RE: Yanco Solar Farm (SSD 9515) – Environmental Impact Statement

ATTACHMENT A - OEH Assessment Summary for Yanco Solar Farm EIS (SSD 9515)

ATTACHMENT B Detailed comments for Yanco Solar Farm EIS (SSD 9515)

Figure 9 Avoidance map showing how isolated find (YSF_IF_001) will not be impacted.

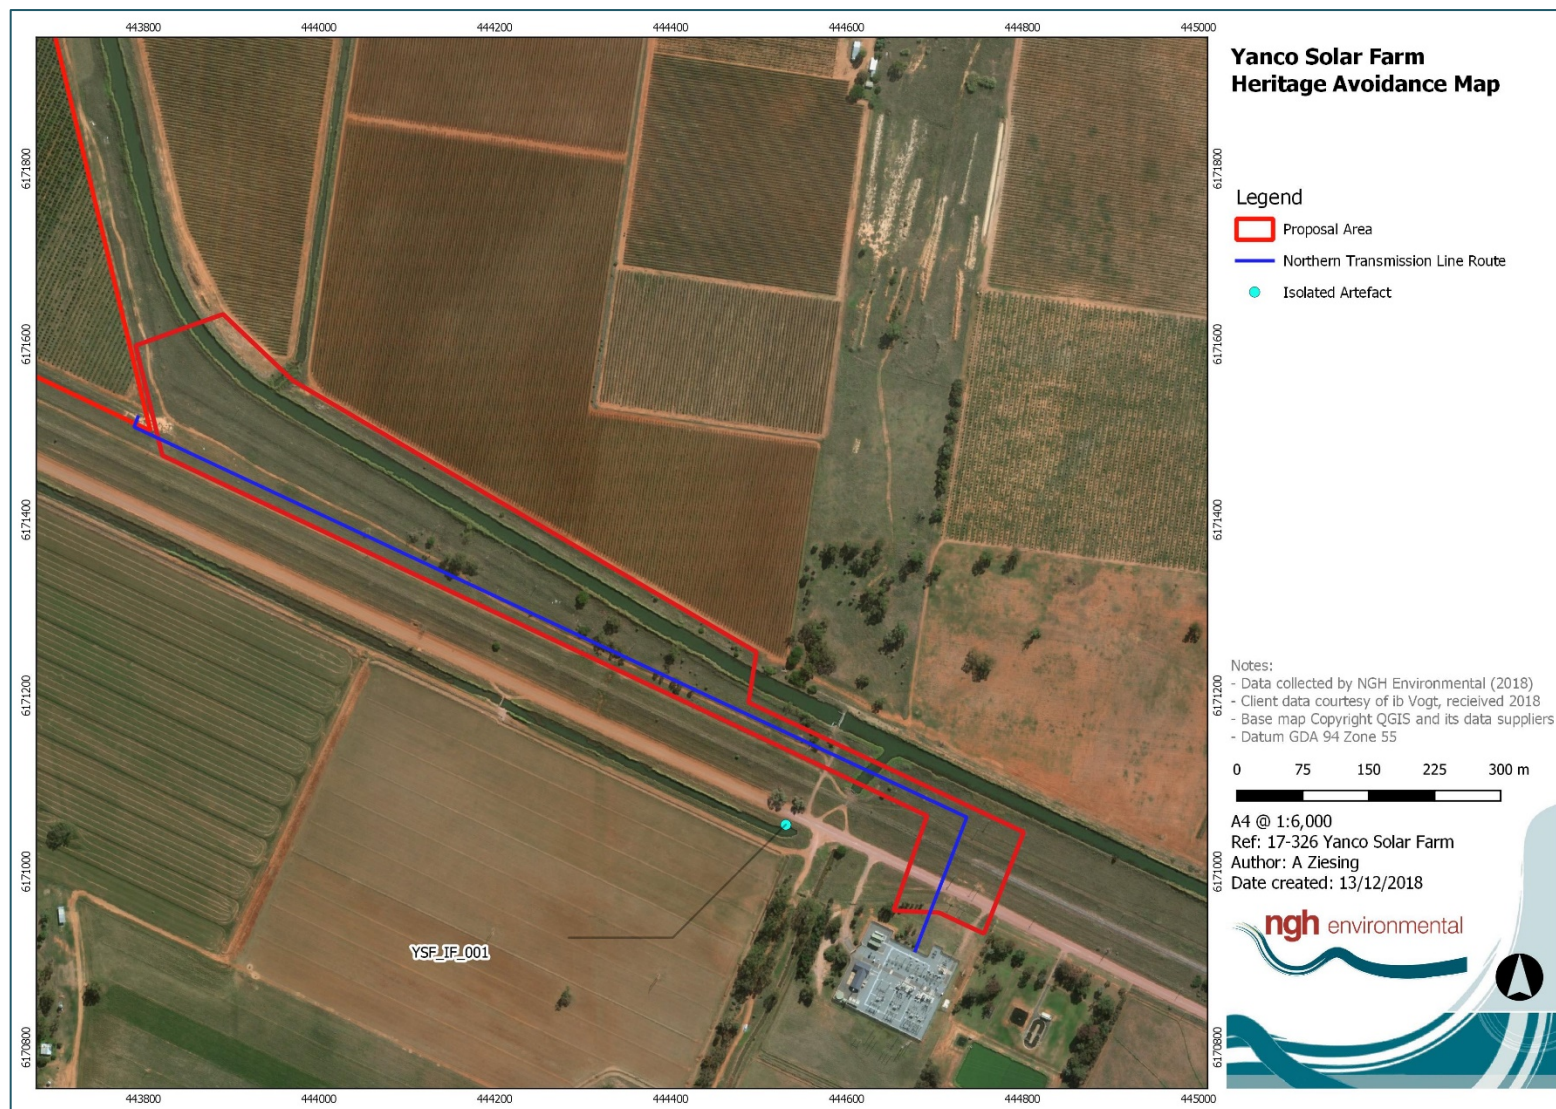
OEH supports the use of the northern transmission line route option to avoid the isolated find, however we consider a risk remains through unintentional harm (i.e. from heavy machinery). We recommend the proponent establish a temporary visible and physical barrier (a high visibility fence) around the object as an added precaution prior to construction and during decommissioning.

- A temporary physical and visible barrier (protective fencing) is to be established around the known artefact prior to any construction in the vicinity
